Environmental Health Division
1675 W. Garden of the Gods Road
Suite 2044
Colorado Springs, CO 80907
(719) 578-3199 *phone*
(719) 578-3188 *fax*
www.elpasocountyhealth.org

Pike Solar 1041, AASI-21-2

Please accept the following comments from El Paso County Public Health regarding the 1,170-acre solar energy facility project referenced above:

FLOODPLAIN CROSSING #3
(66+50-78+00)

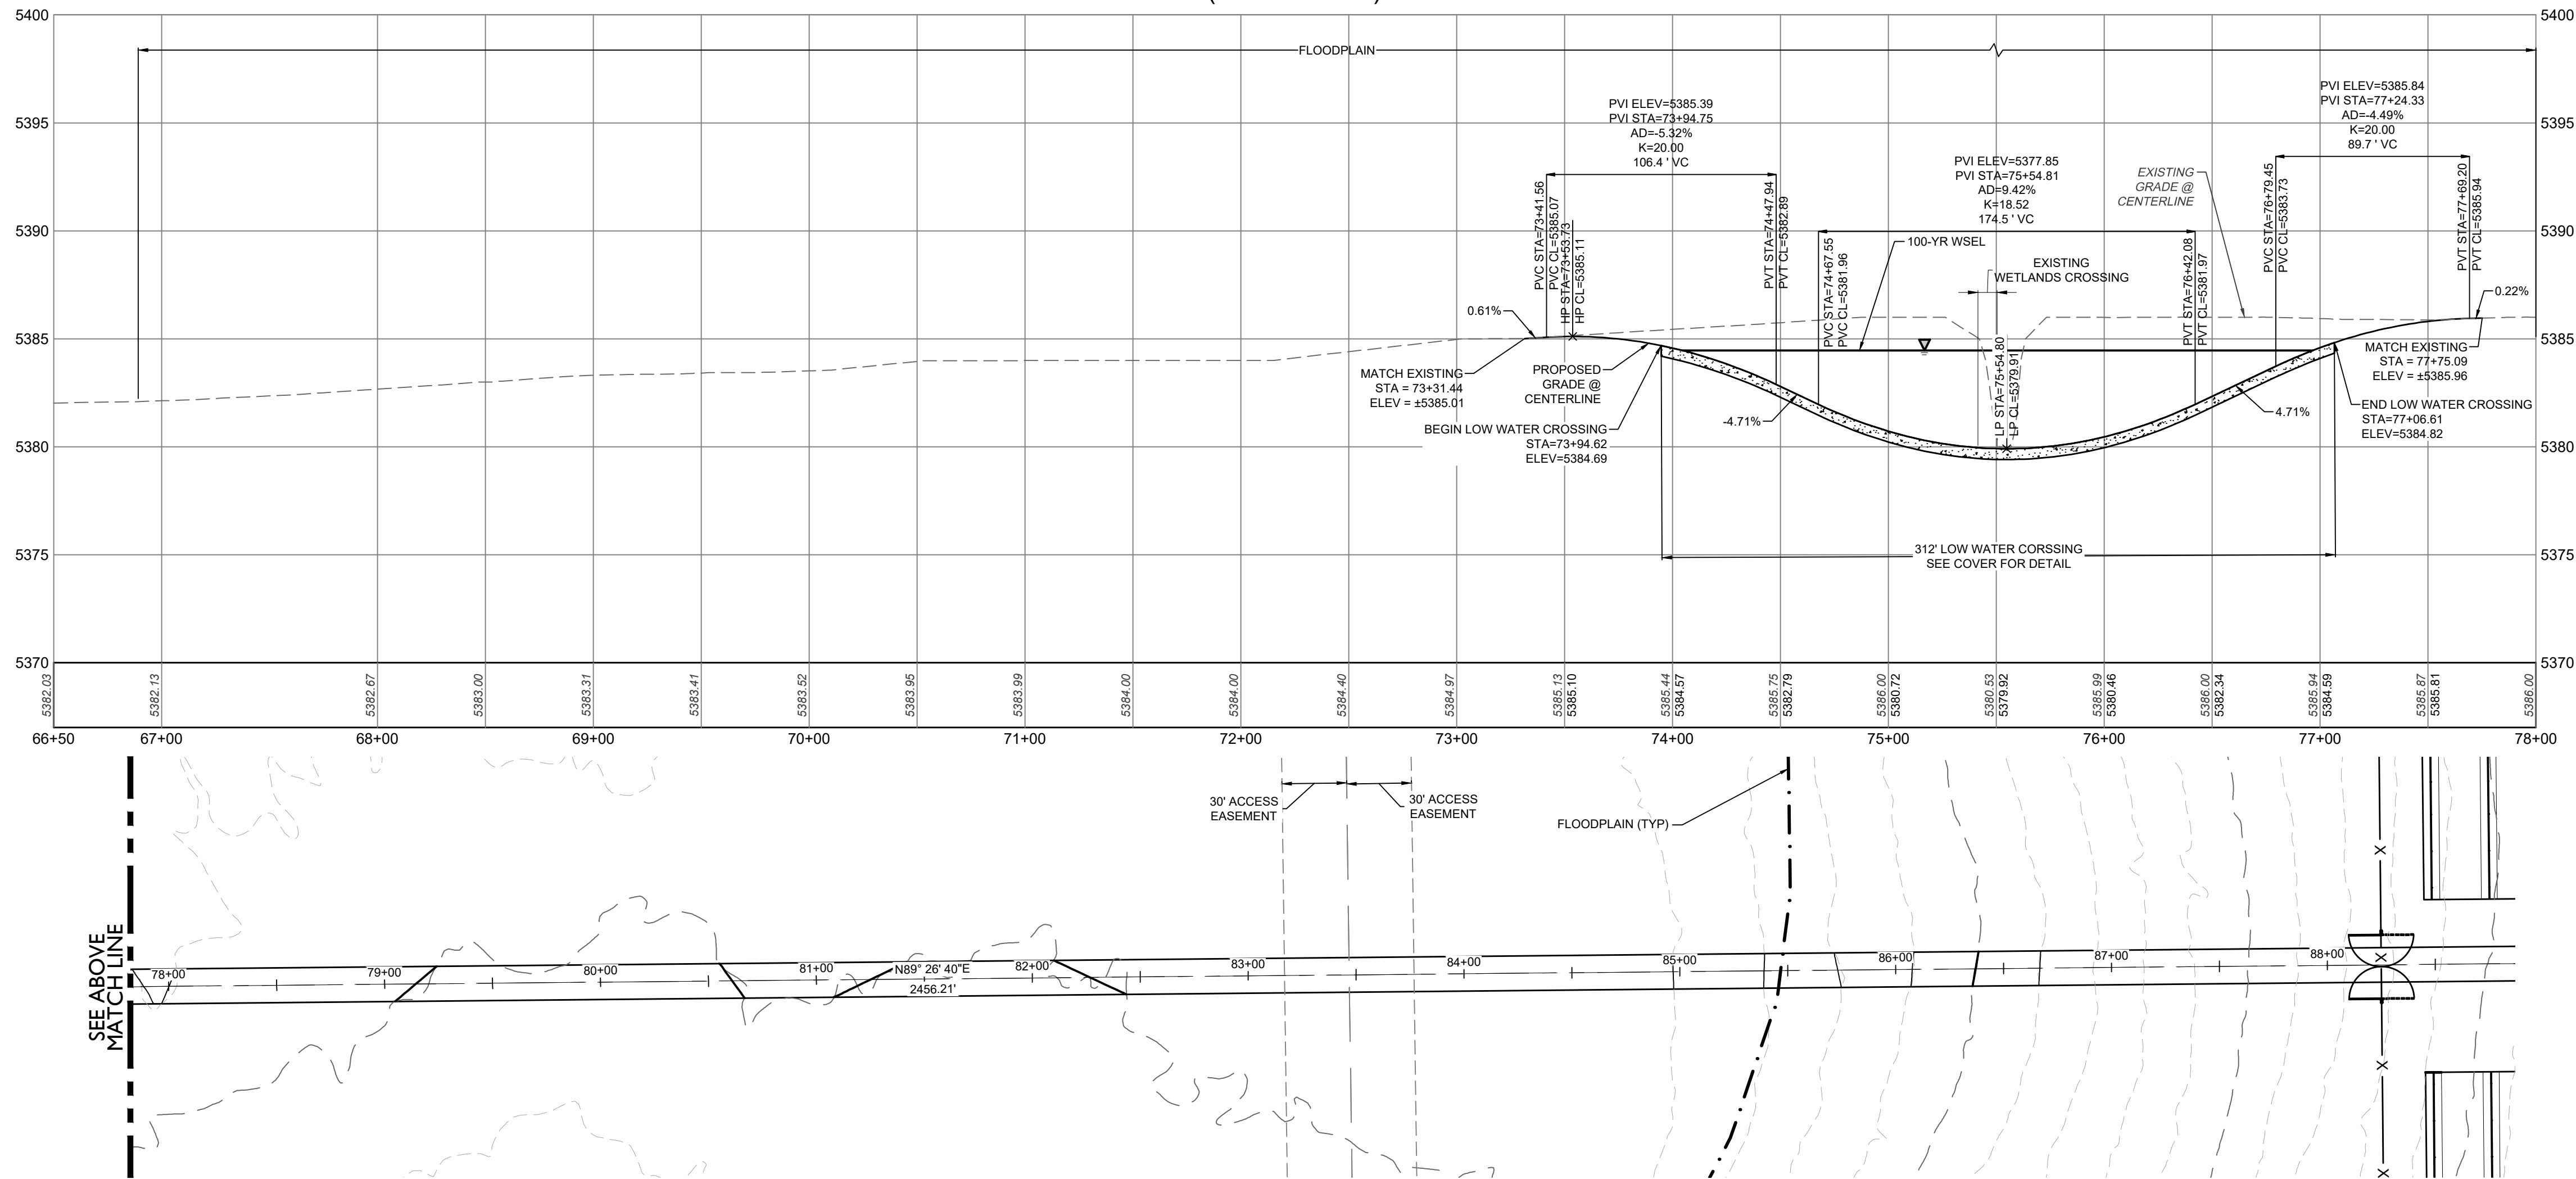
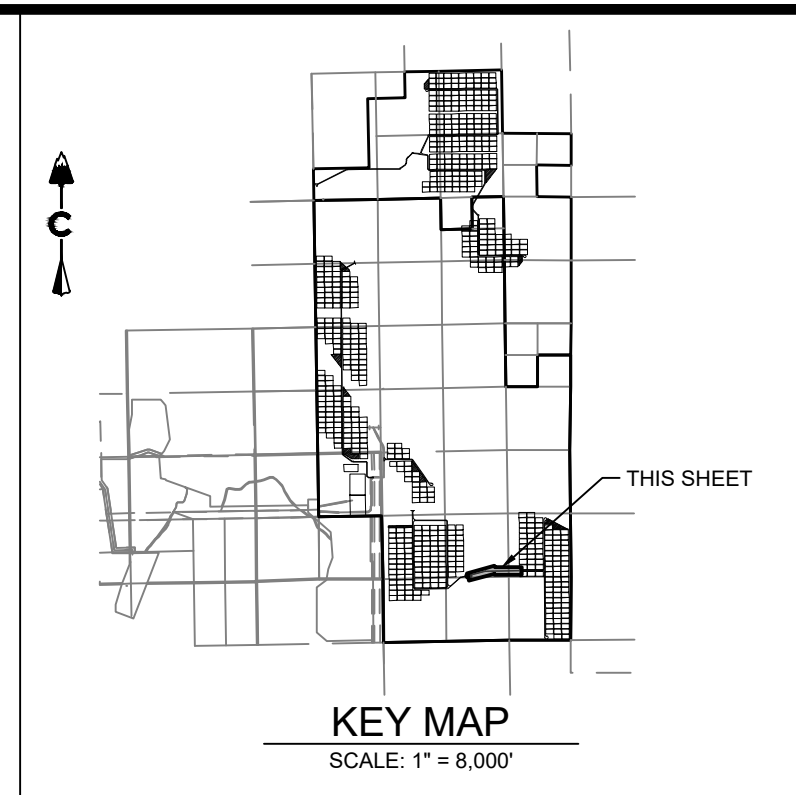
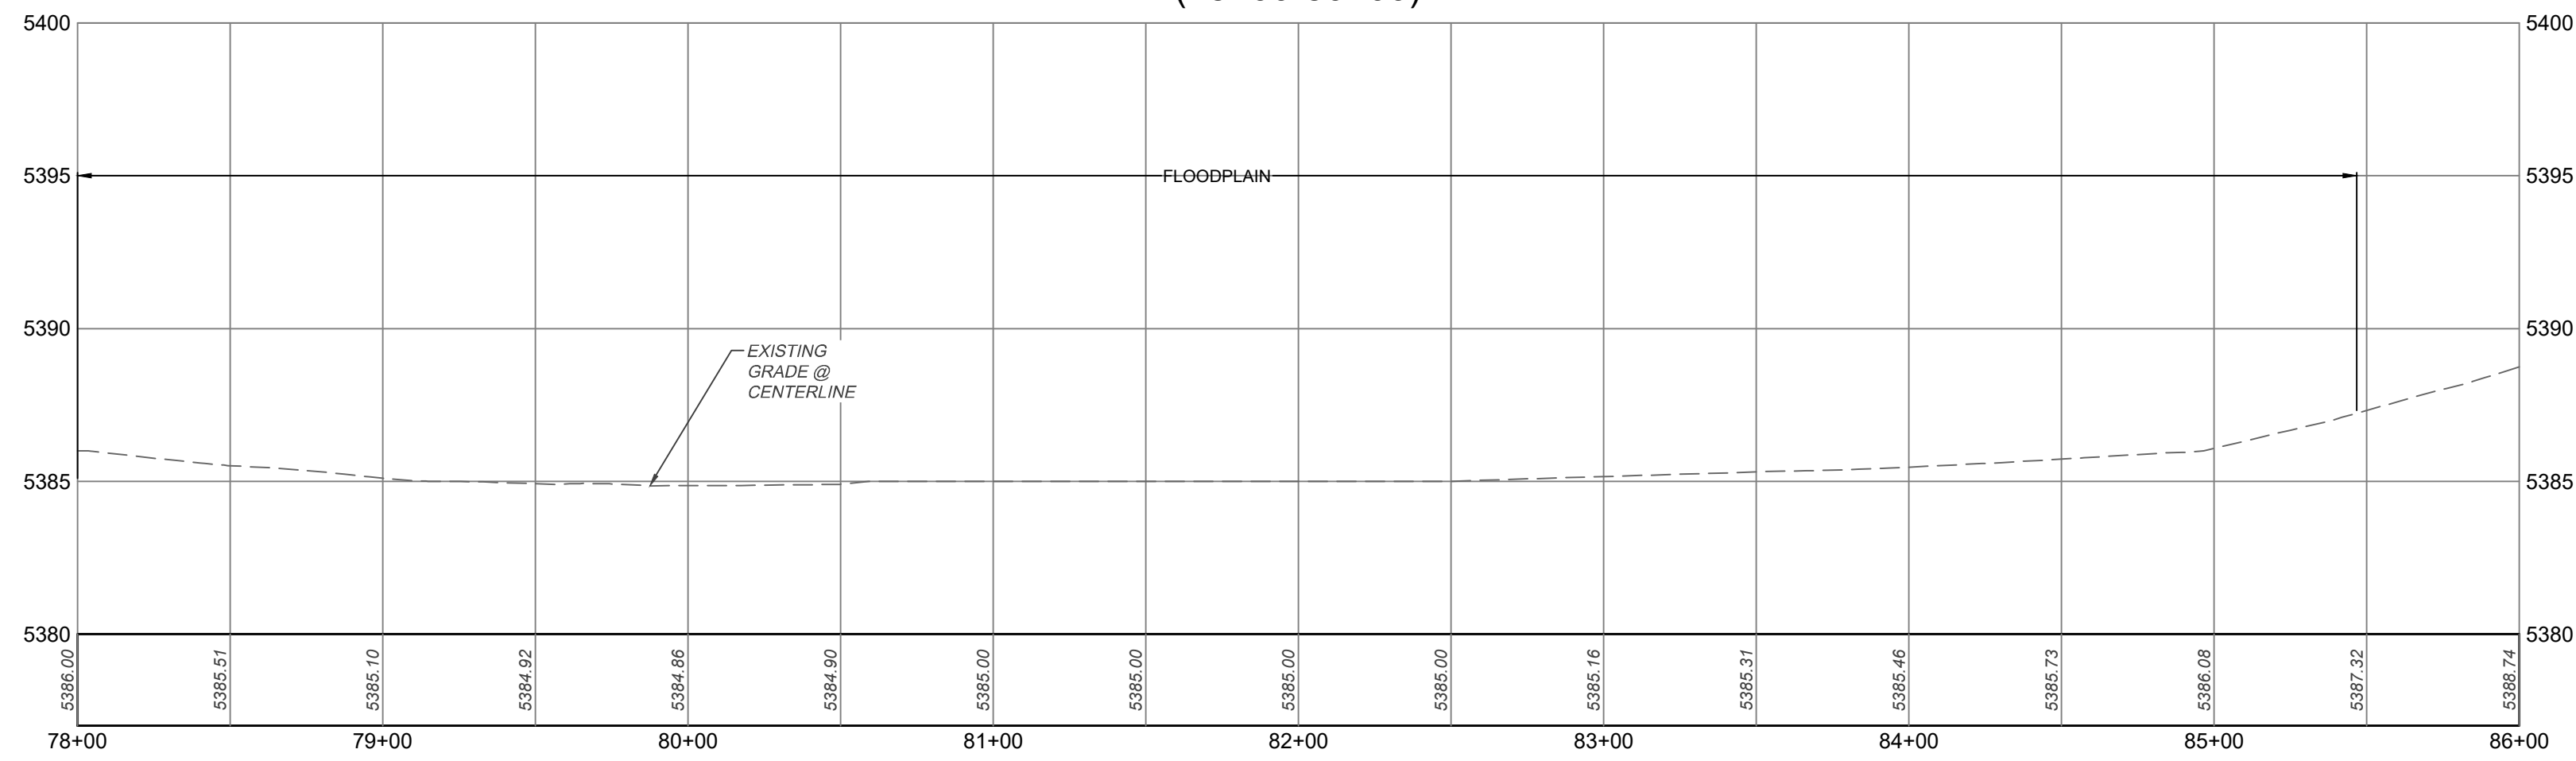
- **The water quality basins must have mosquito control responsibilities included as a part of the construction design and maintenance plan to help control mosquito breeding habitat and minimize the potential for West Nile Virus.**
